Submission by Mallard Pass Action Group (MPAG)

Deadline 8:

**Comments on the Applicant's
Statement on 60 Year Time Limit**

Figure 1 - 0.5% AEP Extents

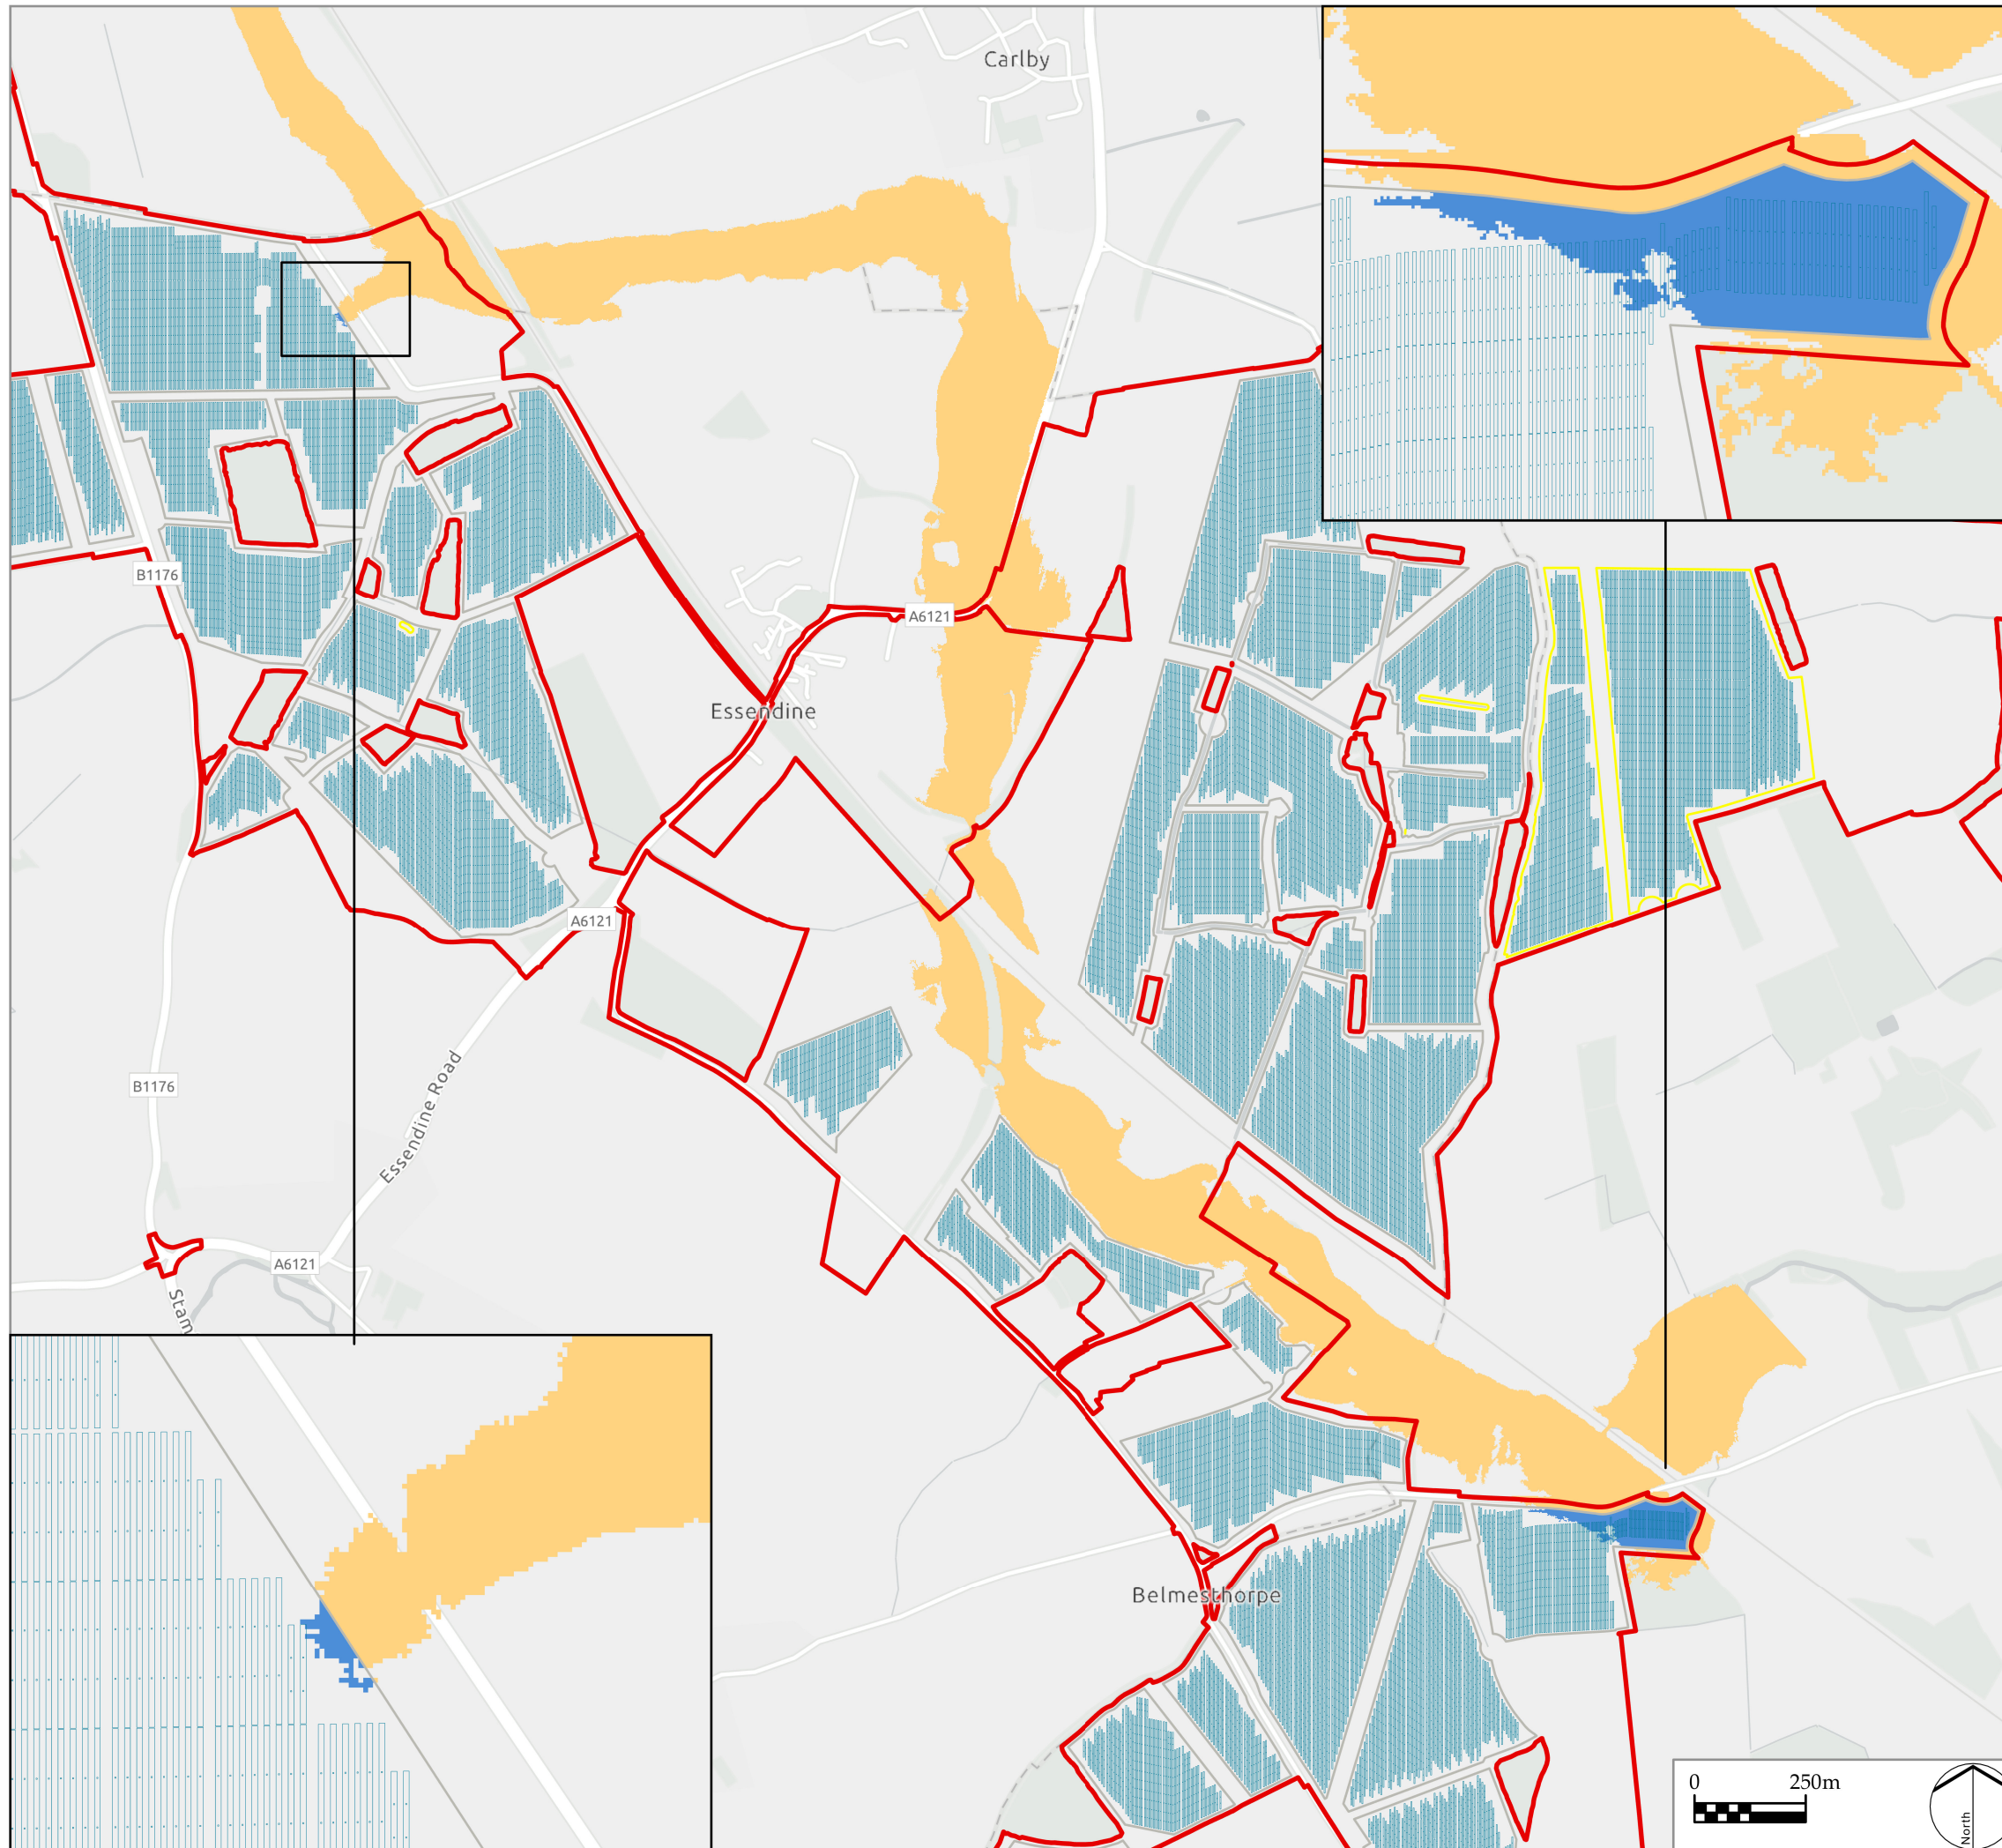
7.1 MPAG are delighted to hear the panels won't get 'wet feet' (so to speak) leading into 2080s by correctly angling the arrays and careful siting near the flood plain, but bitter experience and evidence demonstrates the extent of the flooding experienced over the last 10 years is not reflected in Appendix 1 and 2 to REP7-038 (0.5% AEP depths and Extents).

7.2 Even today as I write this submission (20.10.23) the rainfall today from **storm Babette**, on ground that is relatively dry, is causing **extensive flooding and breaching of the river banks** in places. The peak height of water at Shillingthorpe was indicated as 1.25m during the period 3.15pm – 4.45pm, so within the **Flood Alert (FA) bracket**, as shown on the graph on this link: <https://check-for-flooding.service.gov.uk/station/6027>.

7.4 Luckily the ground has been quite dry recently, so the situation did not upgrade to a flood warning (FW) in the context of Greatford village, just a flood alert (FA). Had it carried on raining into Saturday and Sunday there is no question the outcome would have been very different, the ground would have been unable to absorb the excess water and there would have been more surface water run-off. Storm Babette was relatively kind to this part of England, but the drone pictures taken on Saturday 21st show the extent of the overspill from the West Glen across the site.

MPAG's absolute concern is the speed of run-off from a hard surface, which then dependant on the amount and duration of rainfall is a cocktail spelling 'disaster'. This was only 1 day's rain and it was not torrential.
